City of Portland, Maine - Building or Use Permit

Permit No: 2013-00750	Date Applied For: 04/17/2013	CBL: 128 B024001
---------------------------------	--	----------------------------

Location of Construction: 84 HERSEY ST	Owner Name: LEVINE KAREN E & HOWARD	Owner Address: 27 LANTERN LN	Phone: (207) 774-2221
Business Name:	Contractor Name: Papi & Romano Builders, Inc	Contractor Address: PO Box 1079 Portland	Phone: (207) 797-3381
Lessee/Buyer's Name	Phone:	Permit Type: Additions - Dwellings

Proposed Use: Single Family Home	Proposed Project Description: install a window and window well to add light to basement
--	---

A-101

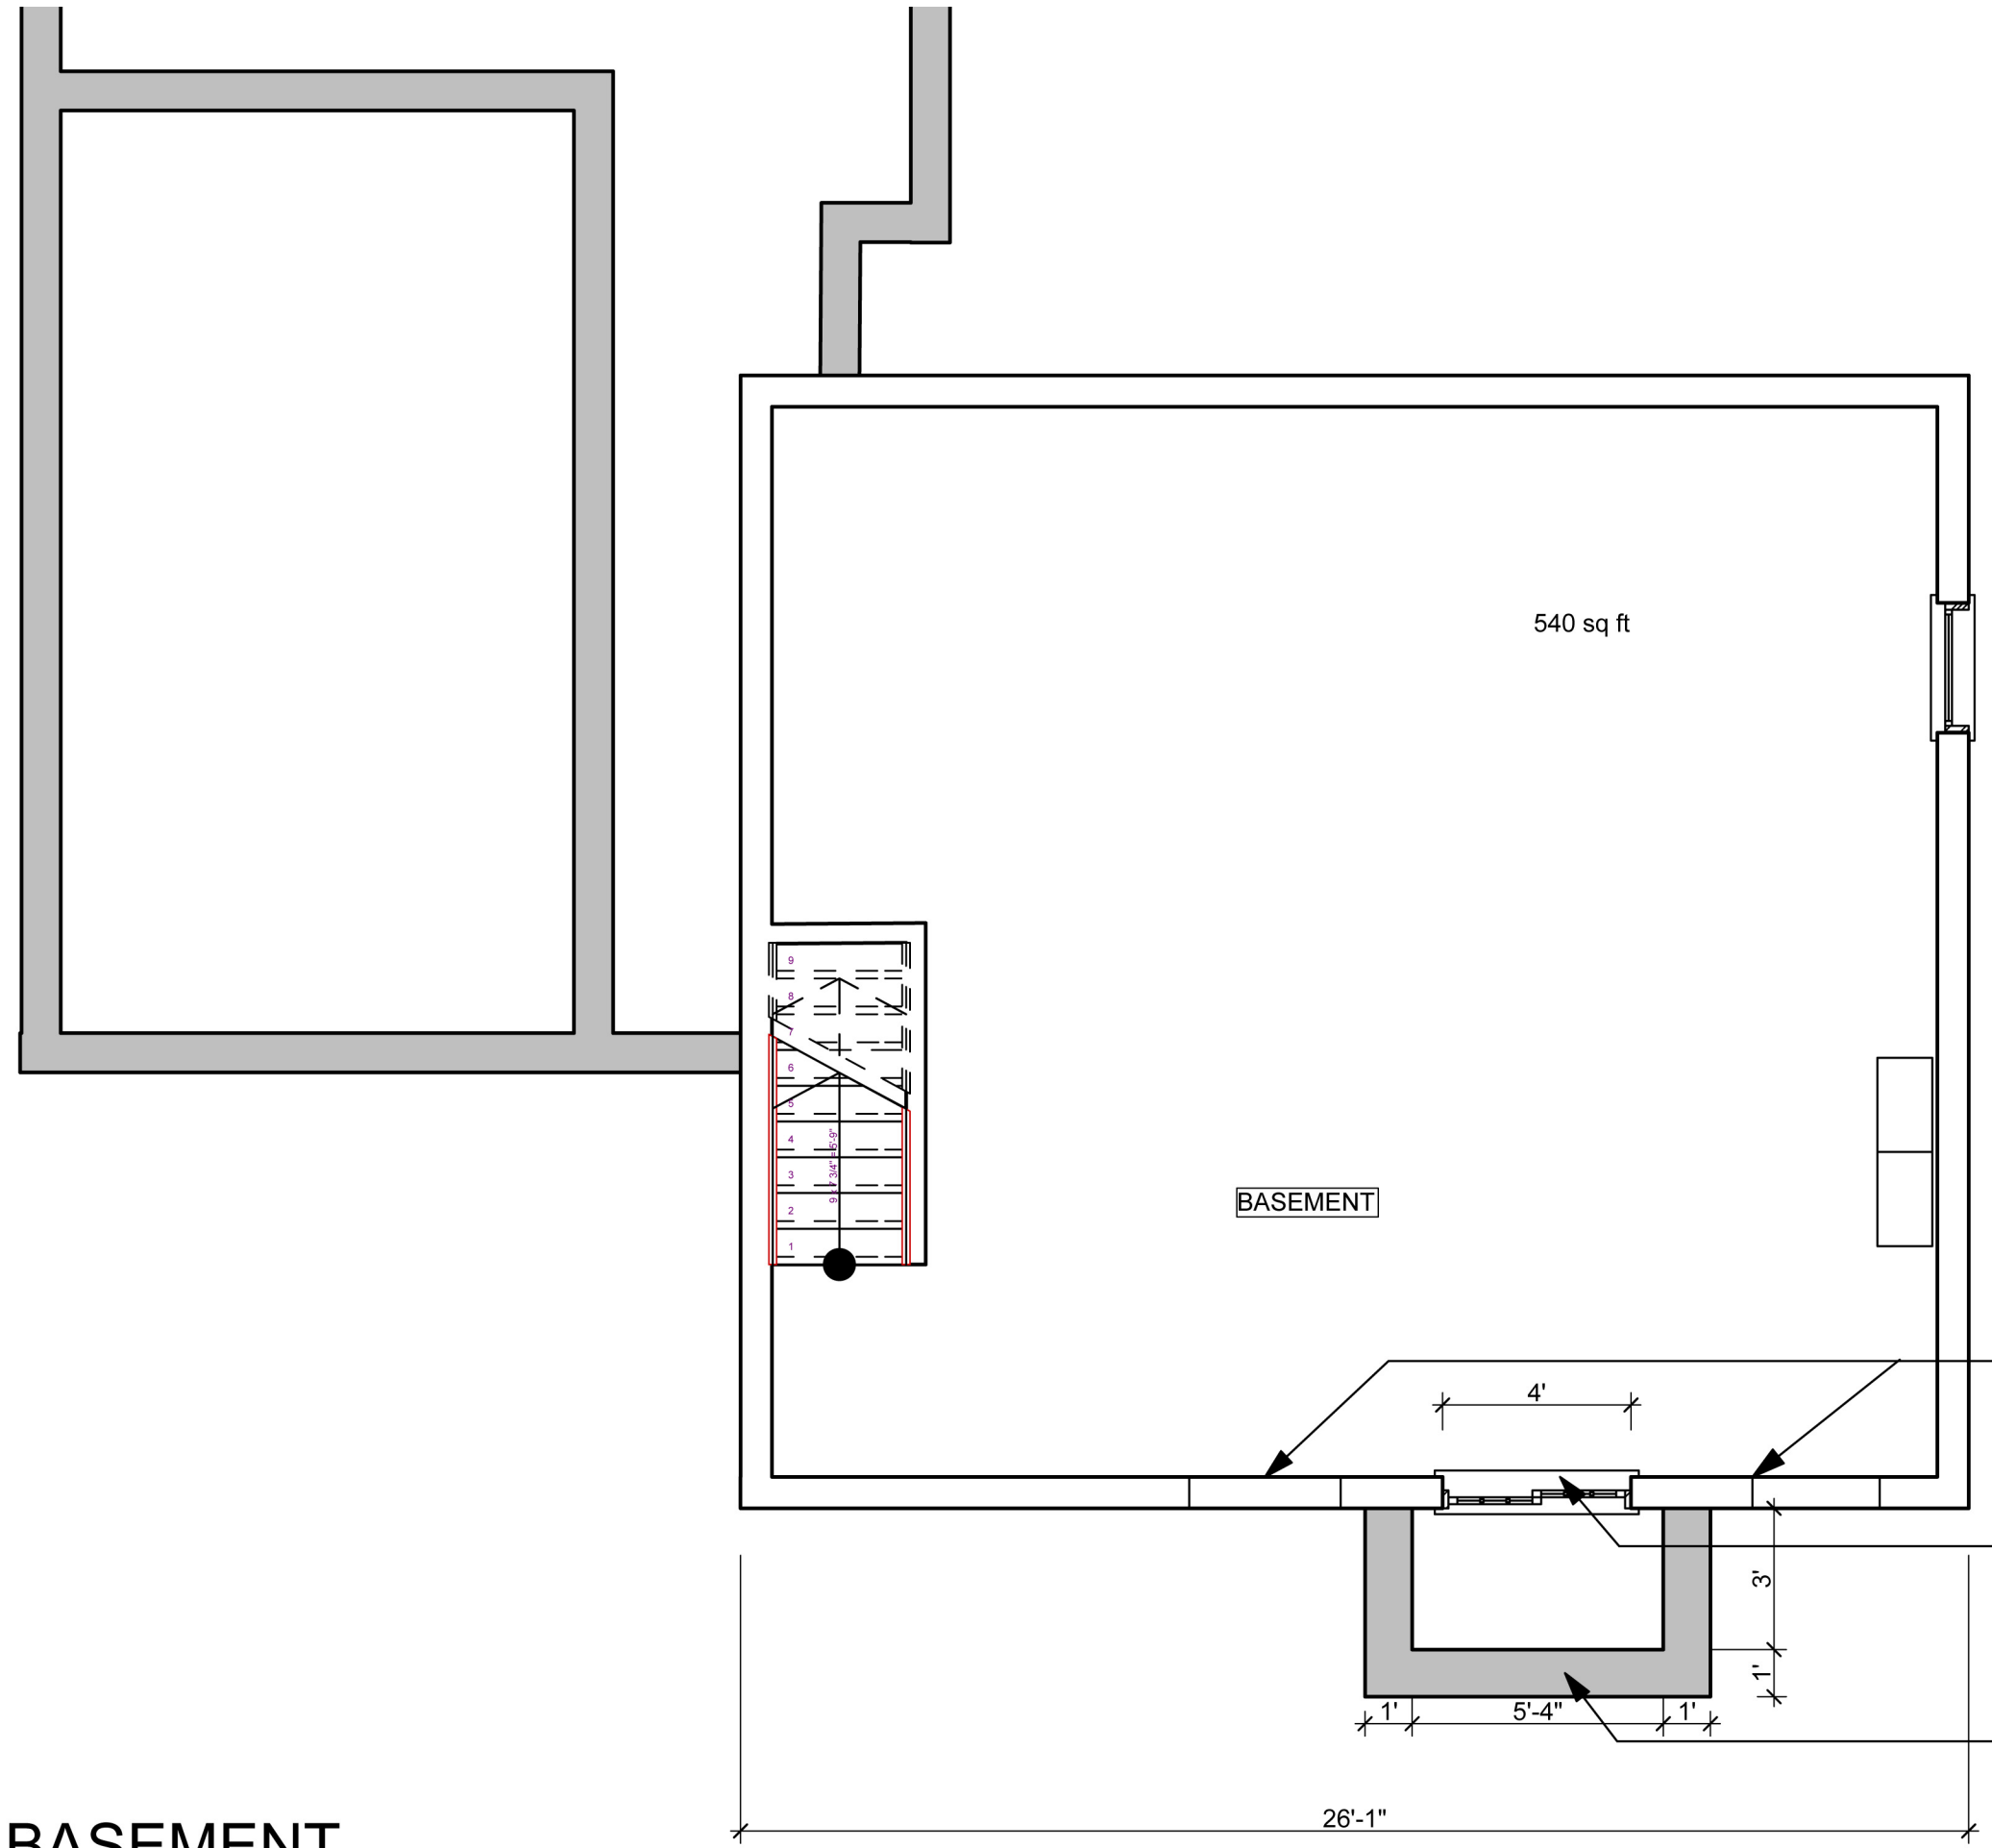
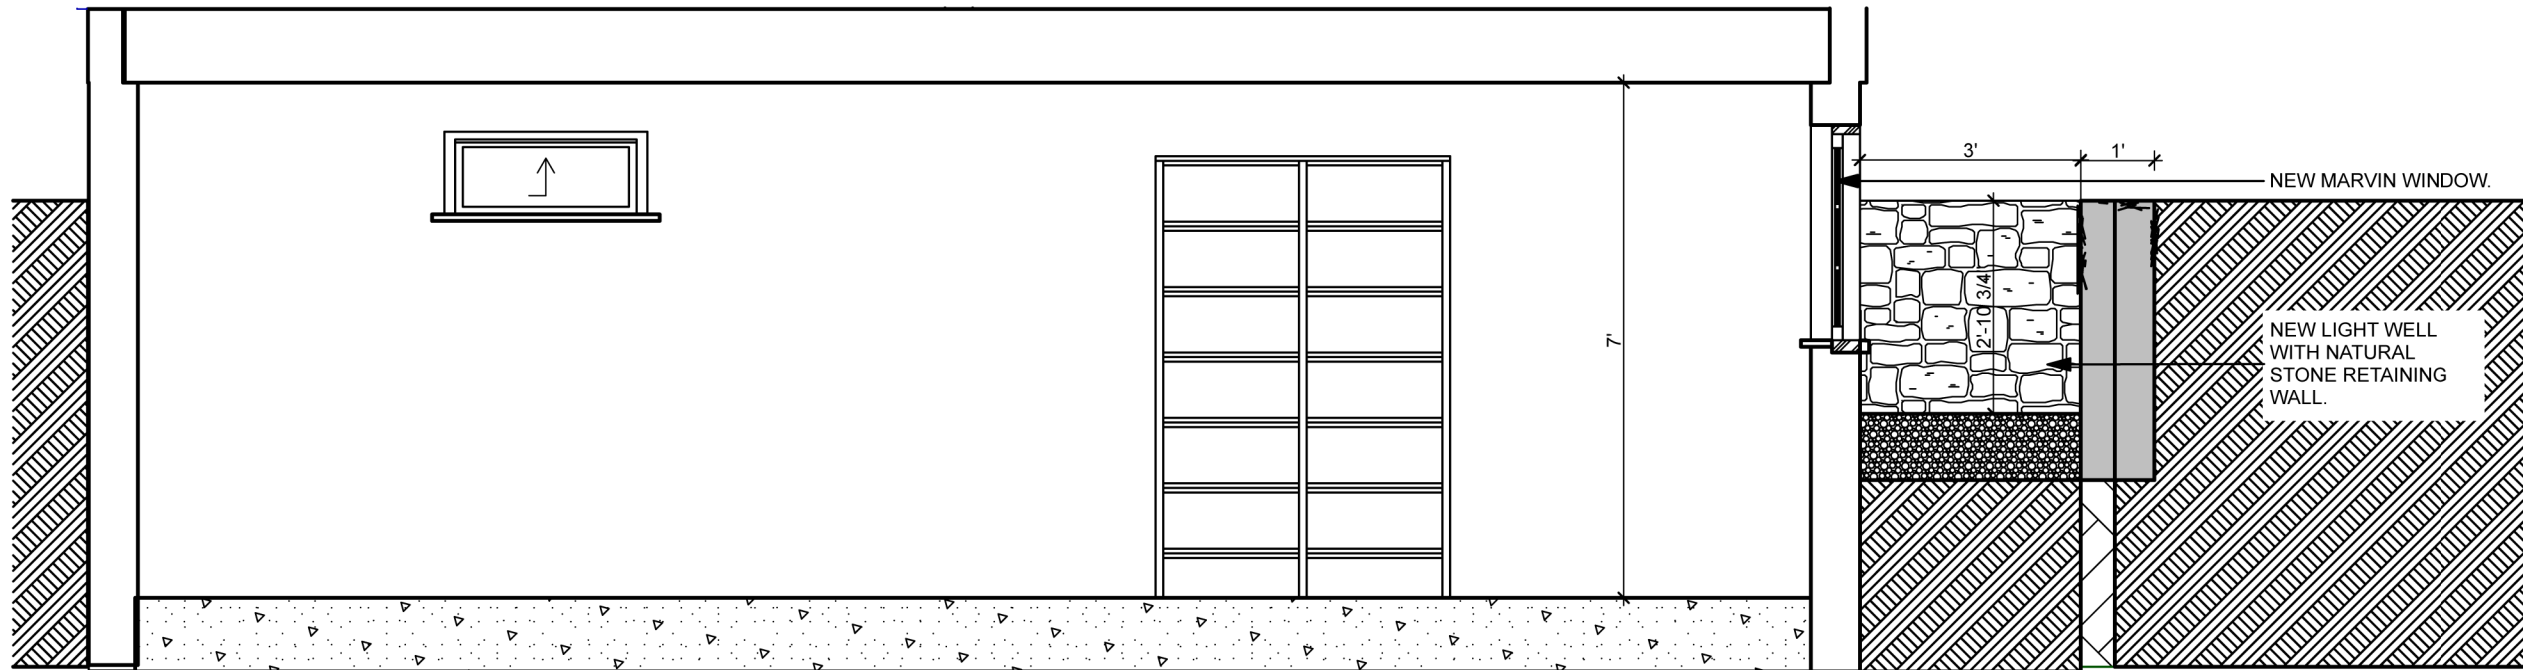
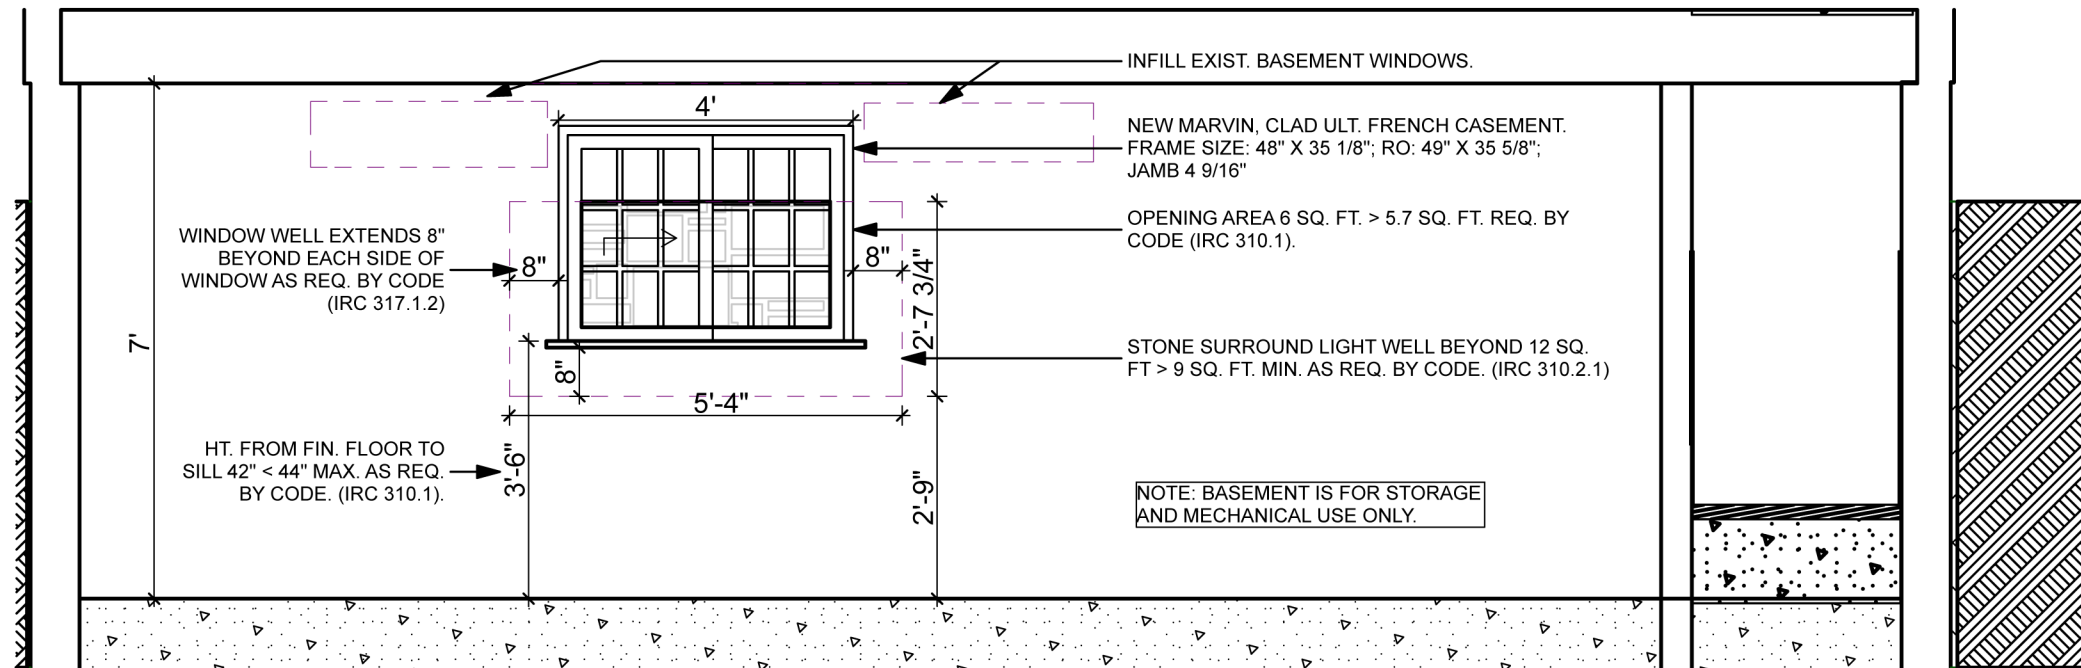
A field inspection will verify your current smoke detector arrangement and the City's minimal code requirements.
- 3) R310.2 Window wells. The minimum horizontal area of the window well shall be 9 square feet, with a minimum horizontal projection and width of 36 inches. The area of the window well shall allow the emergency escape and rescue opening to be fully opened.

Exception: The ladder or steps required by Section R310.2.1 shall be permitted to encroach a maximum of 6 inches into the required dimensions of the window well.

R310.2.1 Ladder and steps. Window wells with a vertical depth greater than 44 inches shall be equipped with a permanently affixed ladder or steps usable with the window in the fully open position. Ladders or steps required by this section shall not be required to comply with Sections R311.7 and R311.8. Ladders or rungs shall have an inside width of at least 12 inches shall project at least 3 inches from the wall and shall be spaced not more than 18 inches on center vertically for the full height of the window well.

- 4) The basement is NOT approved as habitable space. In order to change the use of this space, a code compliant Emergency Escape and Rescue Opening shall be installed per IRC Sec. R310. A separate permit is required.
